# **Together Against Sizewell C**

Comments on EDF's Proposals for Rail Based Transport of Materials for Construction of Sizewell C Power Station.

# **Comments on EDF's Proposals for Rail Based Transport of Materials for Construction of Sizewell C Power Station**

Author: Clive Lovelock

DRAWING TITLE:
KNODISHALL LEVEL CROSSING
EXISTING GENERAL ARRANGEMENT

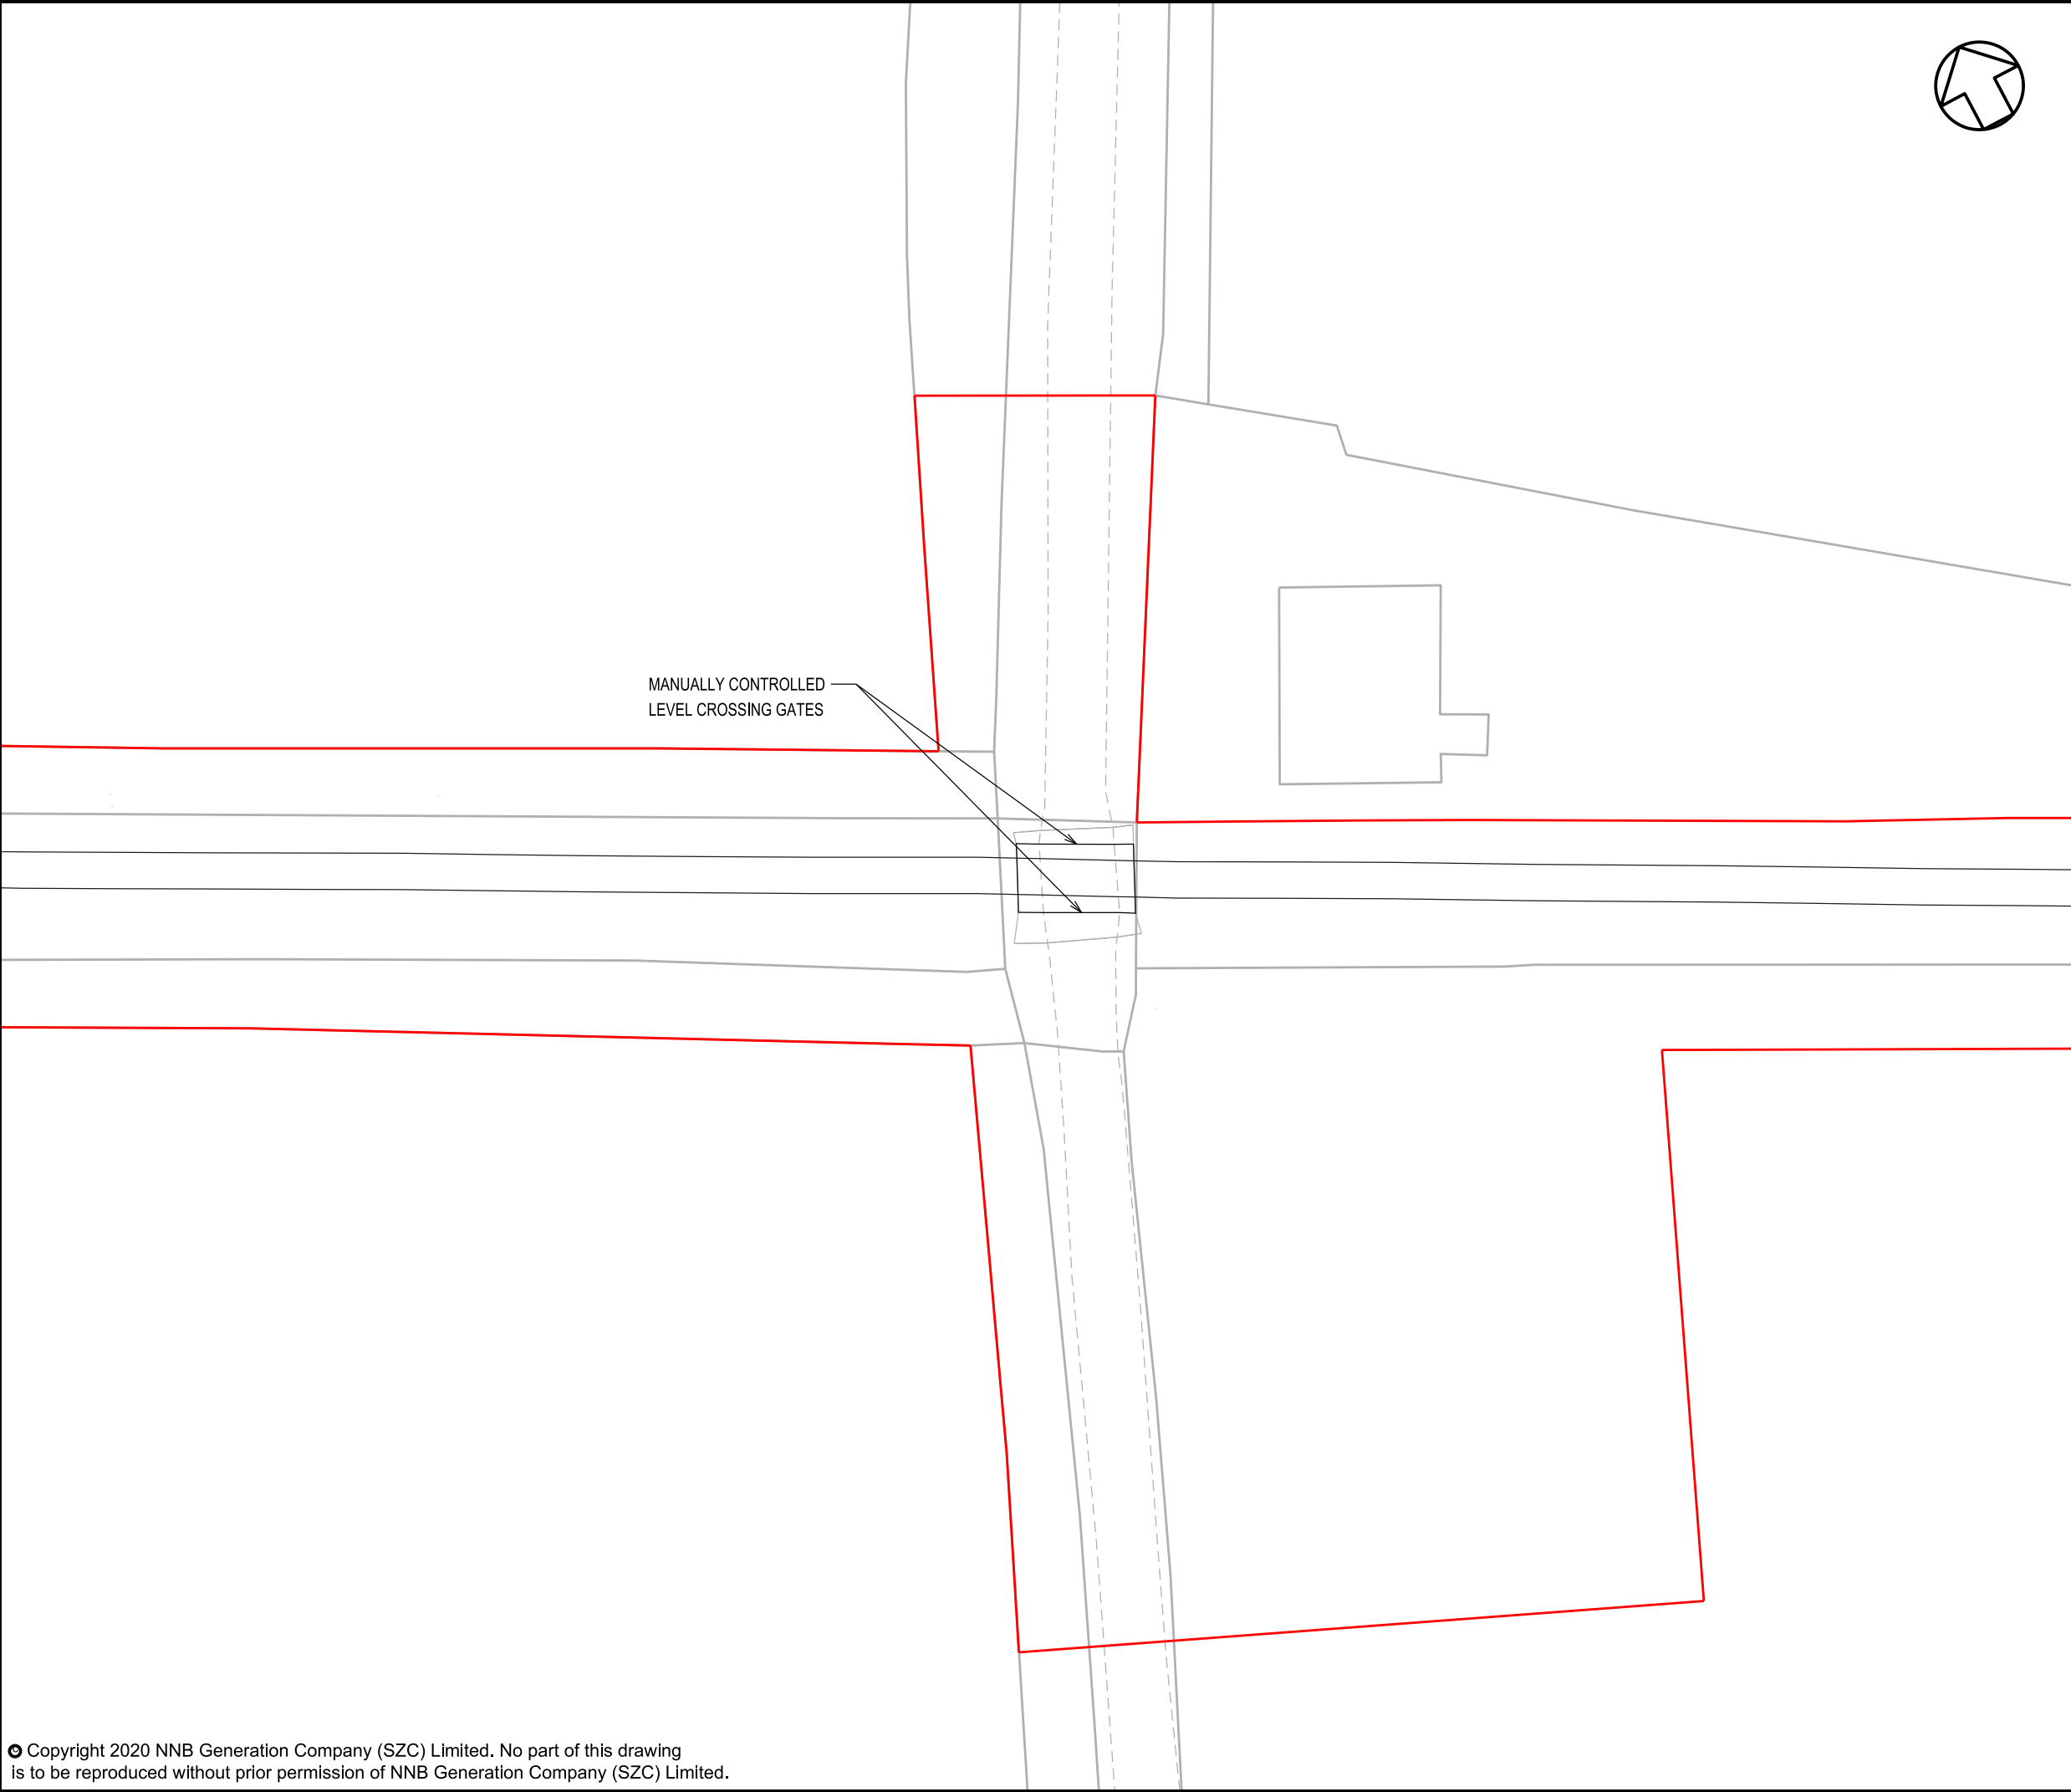
- Eight level crossings on the branch will be improved. This is principally to eliminate the need for train crew to bring their train to a stand at a crossing and then manually open and close gates for the train. Three existing trainman operated gated crossings at Knodishall L.C., West House L.C. and Saxmundham Road L.C. will be converted to Automatic Barrier Crossings- Locally Monitored (ABCL) The existing gated crossing adjacent to the old Leiston station will be converted to full lifting barriers operated by a member of the train crew.

The above proposals seem to be appropriate for the rail traffic envisaged, the permitted axle weight is suitable for the freight loads envisaged and the use of CWR will reduce the noise of the trains. The level crossing protection proposed conforms with the current requirements laid down in the ORR's document "Level Crossings: A guide for managers, designers and operators" Railway Safety Publication 7, December 2011.

DRAWING TITLE:
SAXMUNDHAM ROAD LEVEL CROSSING
EXISTING GENERAL ARRANGEMENT

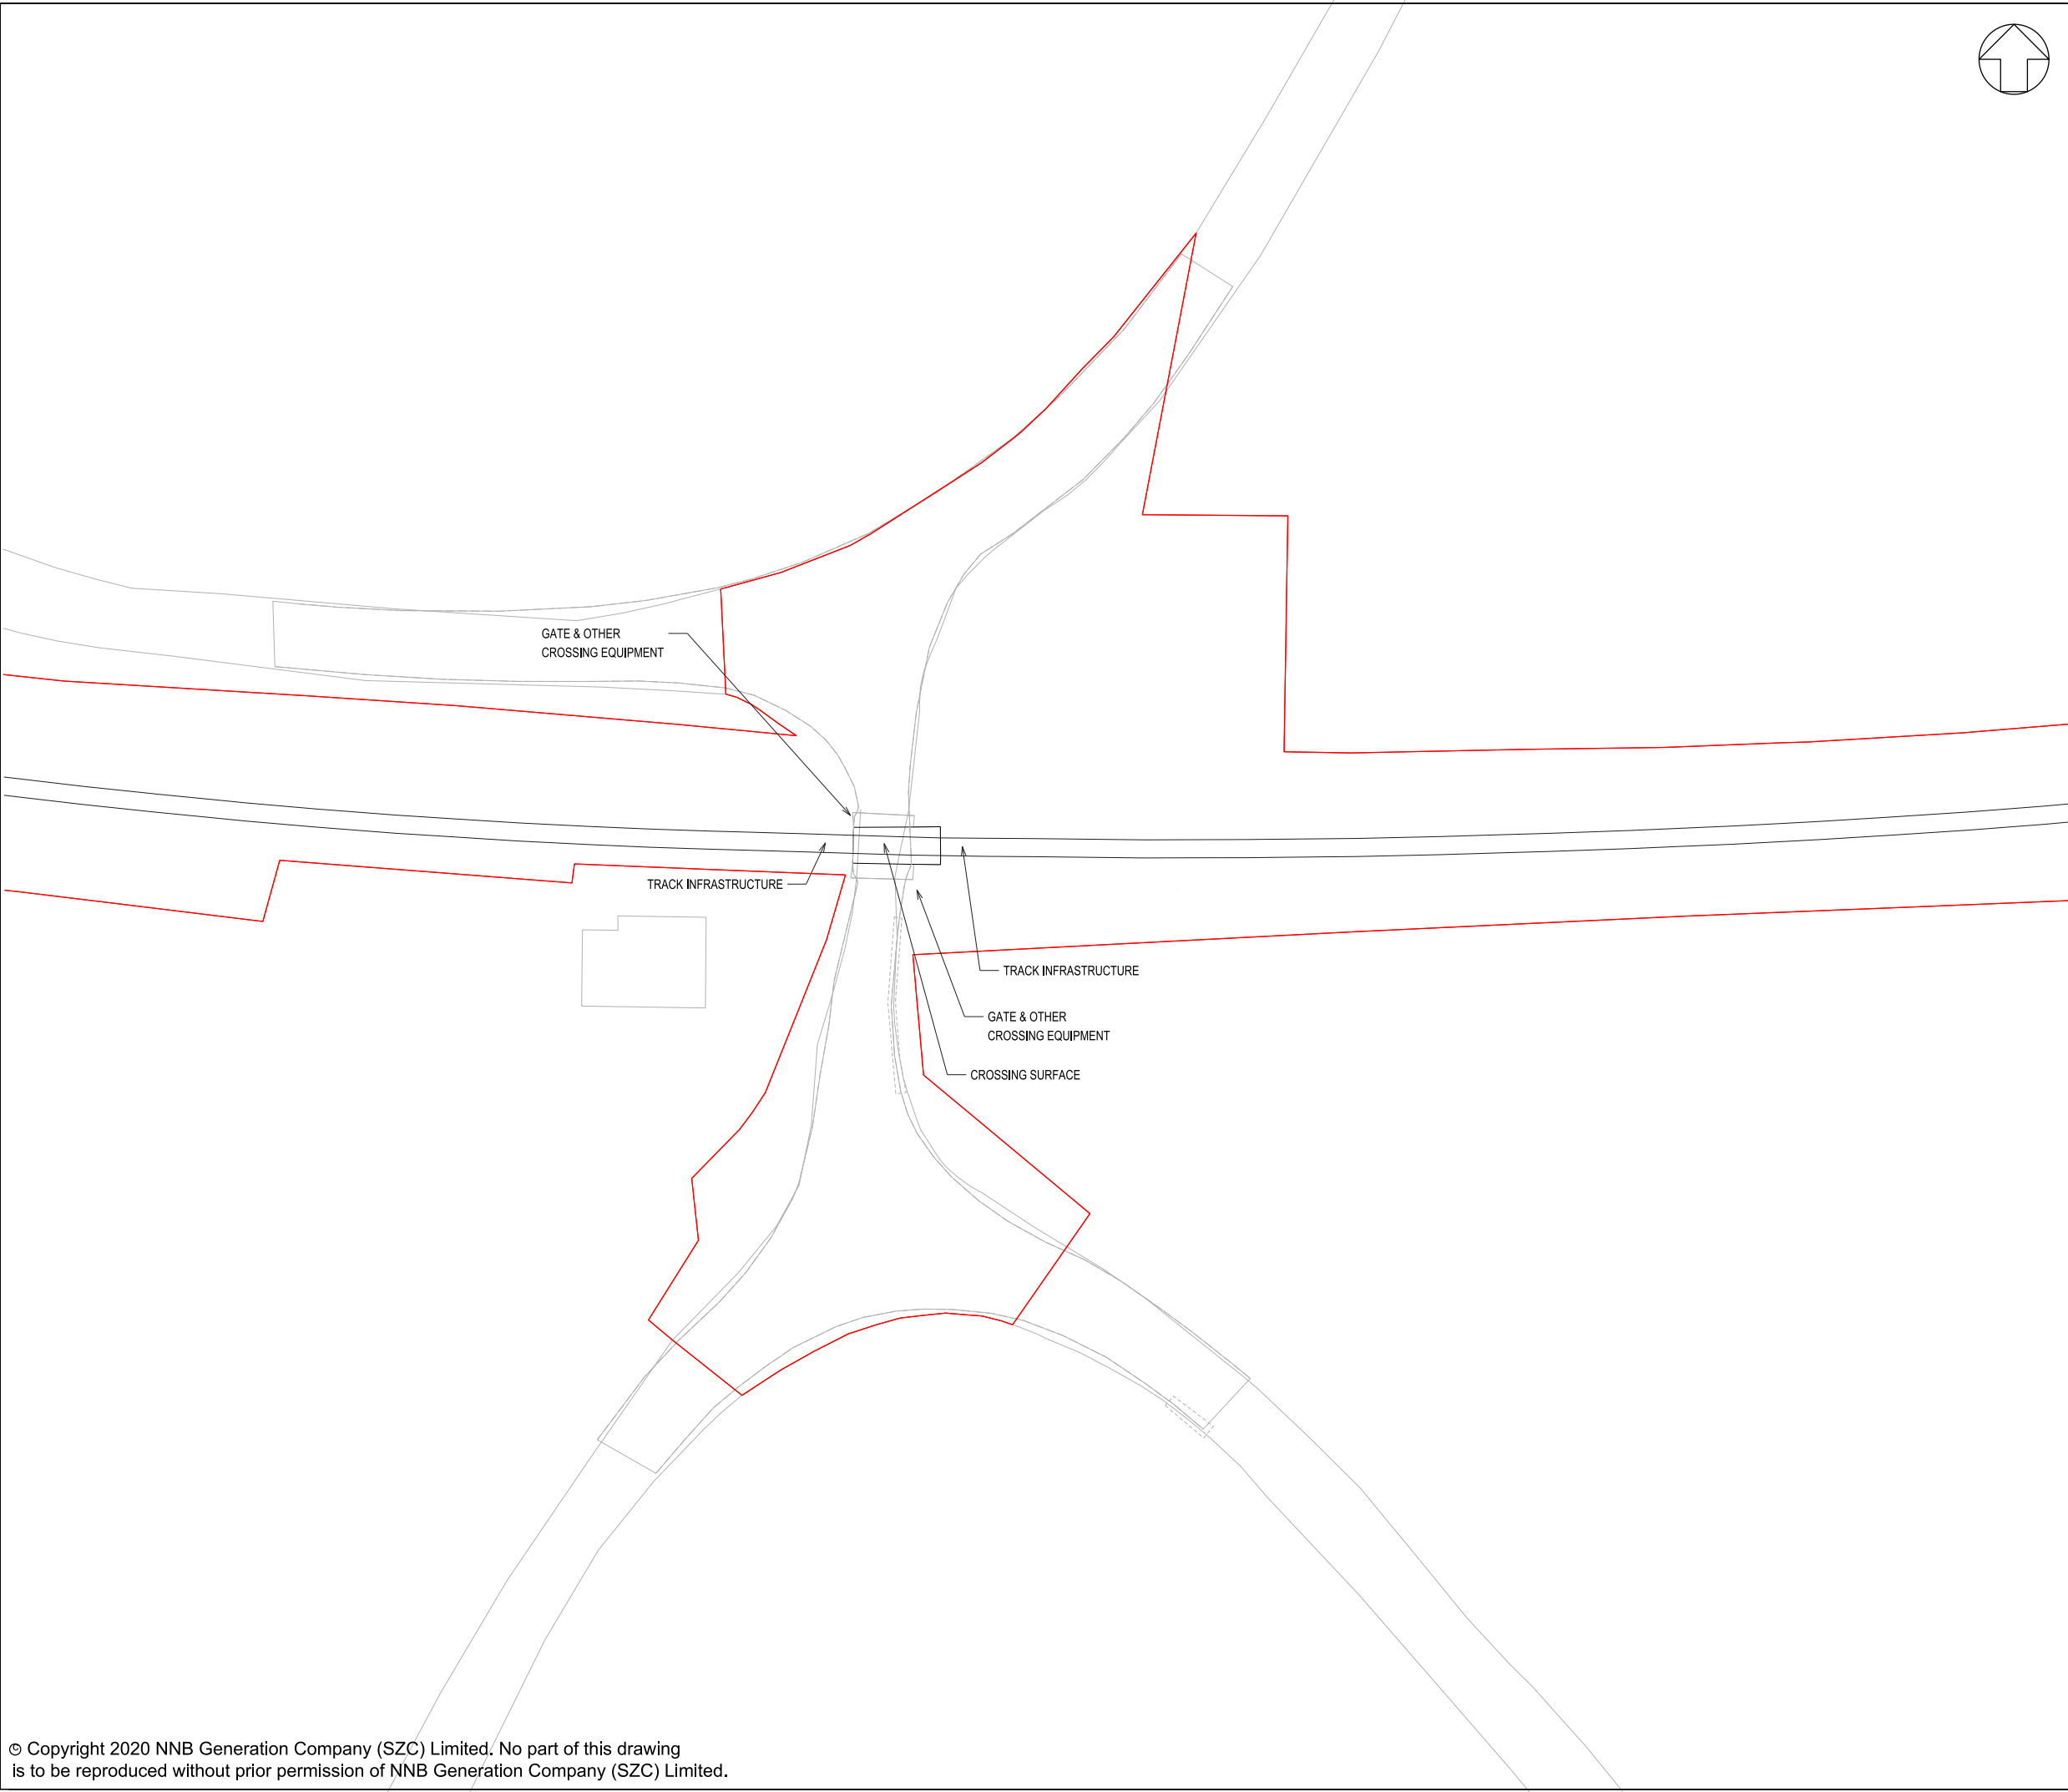
- A new branch "the Green Route" approximately 4.5 km long will diverge from "The Branch" at a point between Saxmundham Road Crossing and Buckles Wood footpath crossing and run in a north easterly direction crossing Buckles Wood Road and Abbey Road. Both crossings will have full barriers and obstacle detectors.
